PLANNING APPLICATION FORM - CONTINUATION SHEET

QUESTION 6. Condition(s) – Removal

Condition 2

Job No.:	Dwg No.:	Stage:	Revision:
031601	PD09	Planning	P2

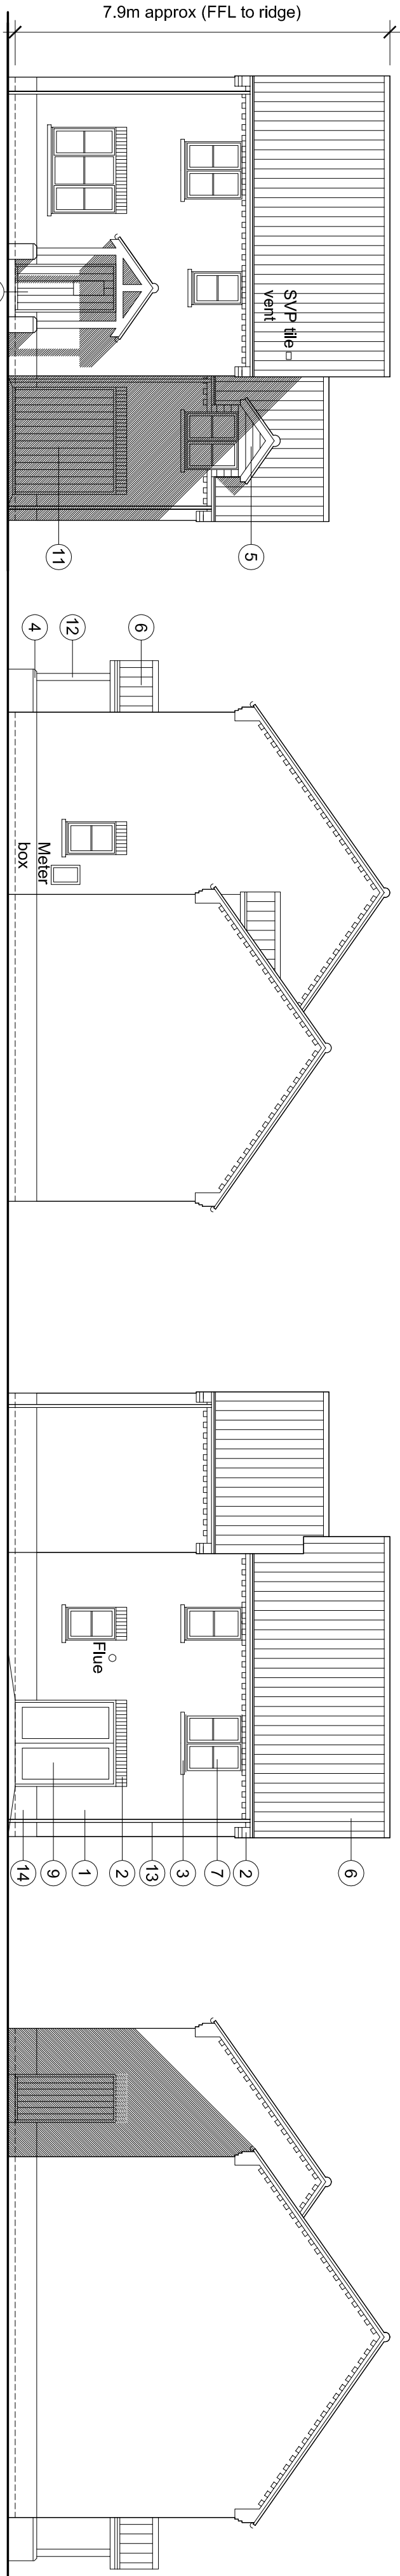
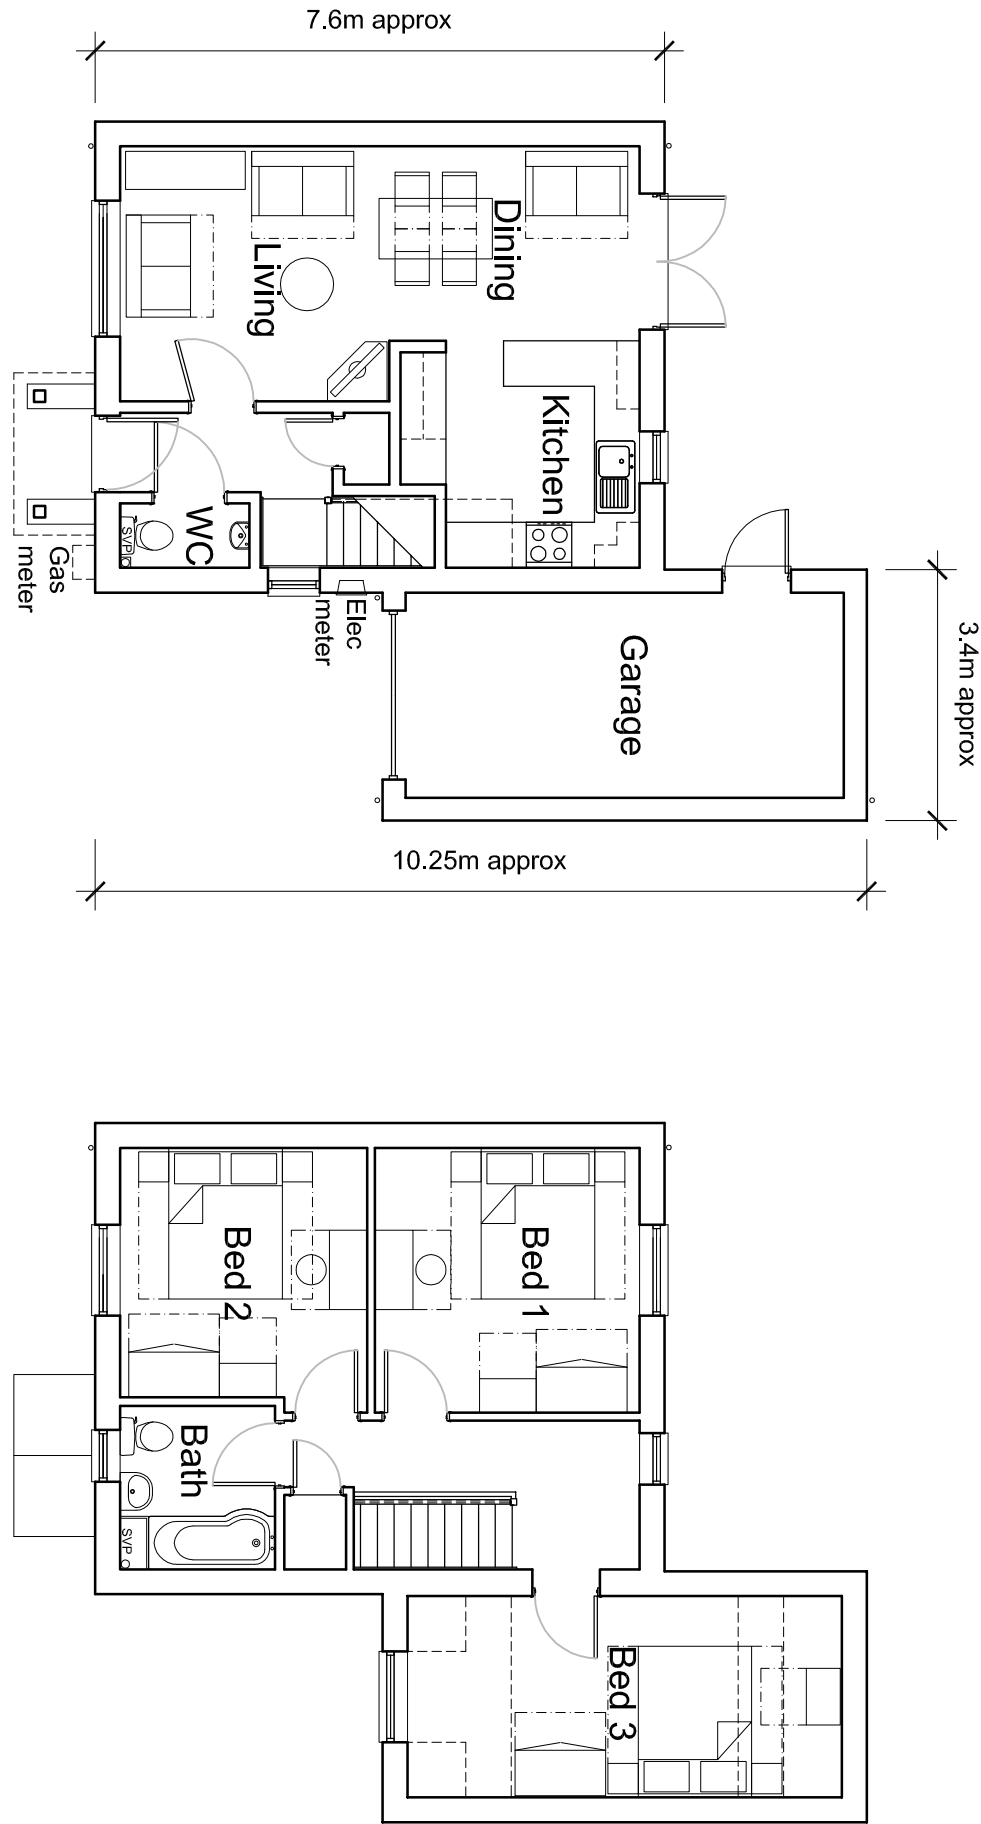
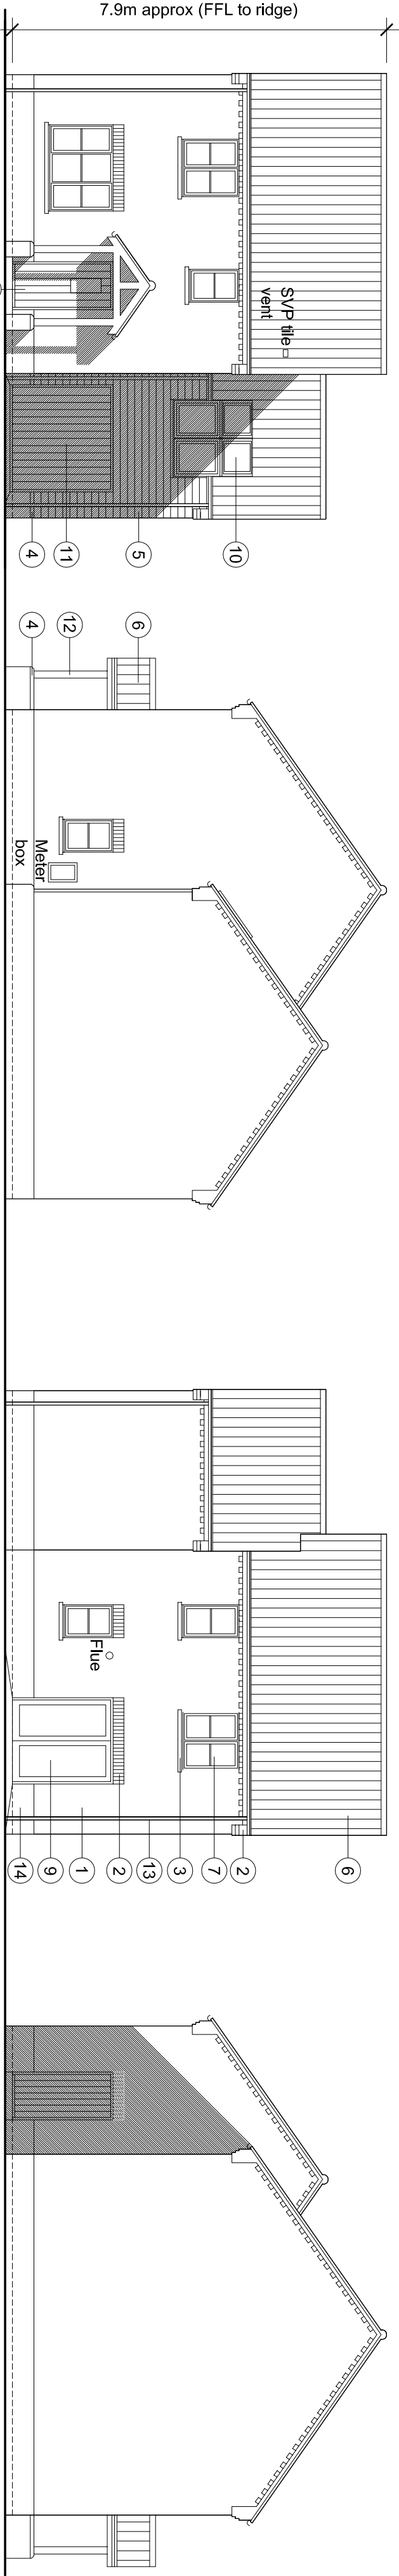
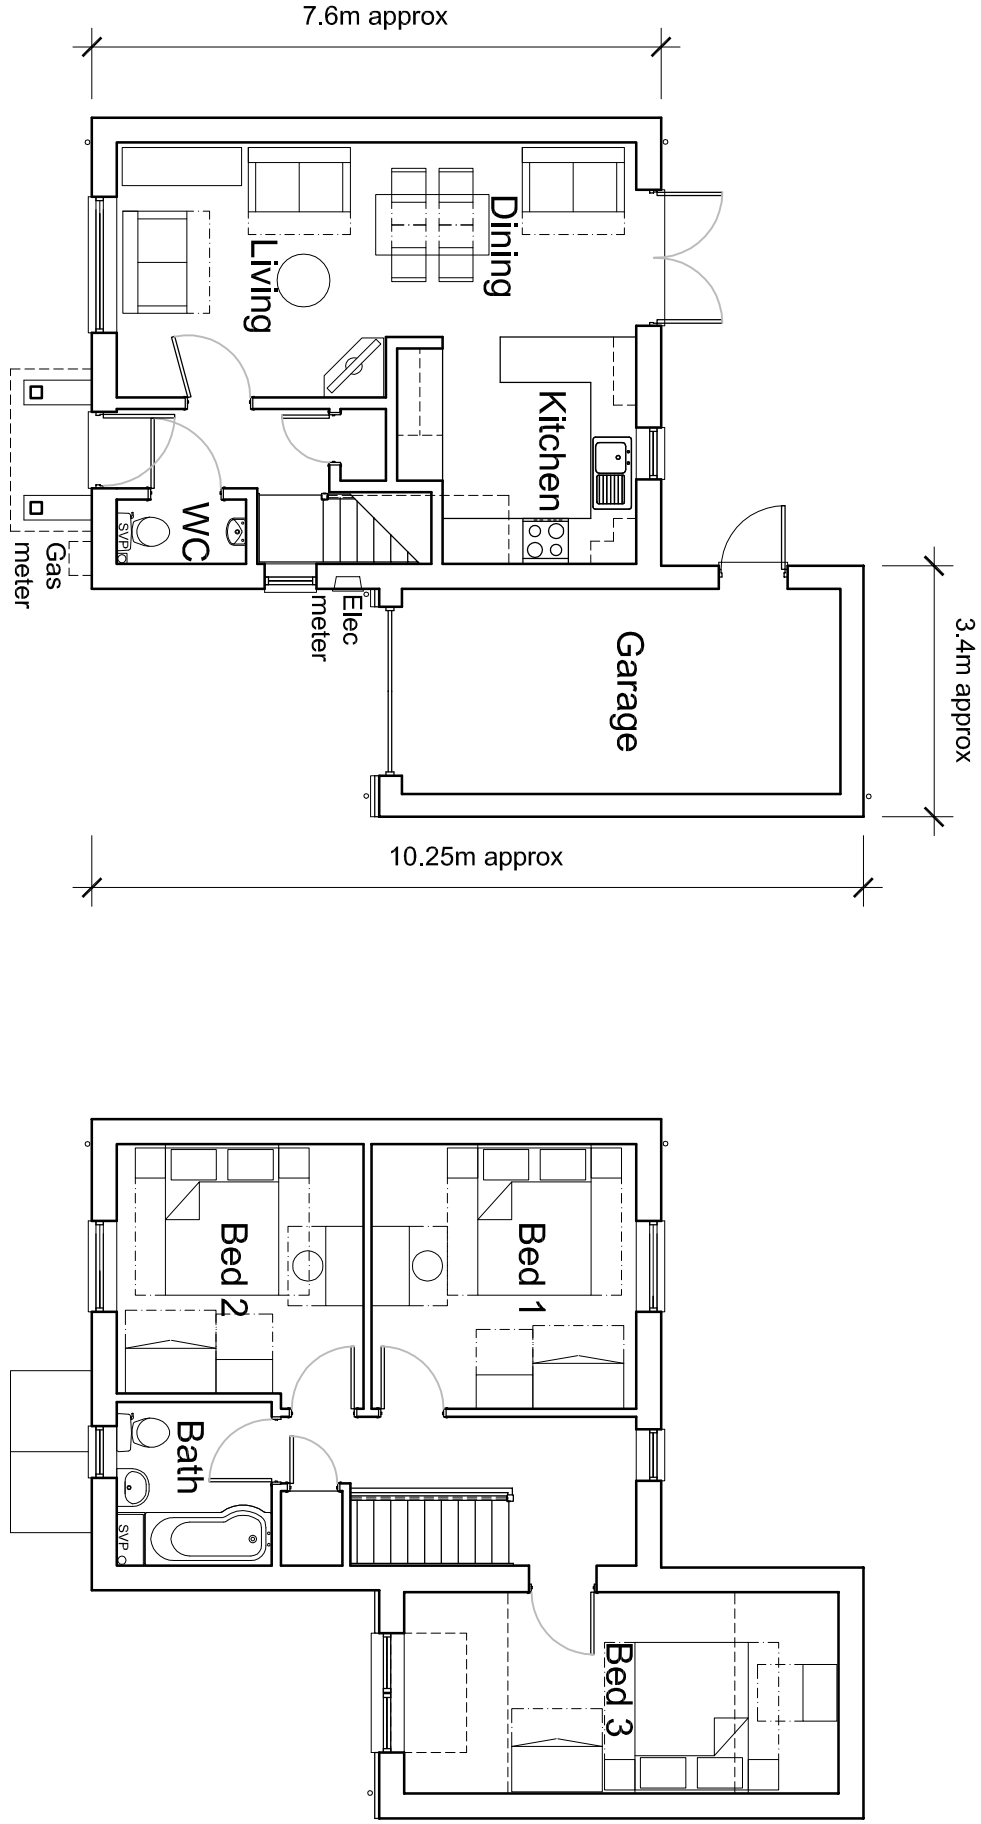
PD06, PD07, PD08, PD09, PD10 & PD11 are changed to show the addition of meter boxes, gas flues and soil vent pipes. In addition drawing PD08 is changed to show widened properties. In addition drawing PD11 is changed to show revision to plot 32 to be same bungalow type as plot 33.
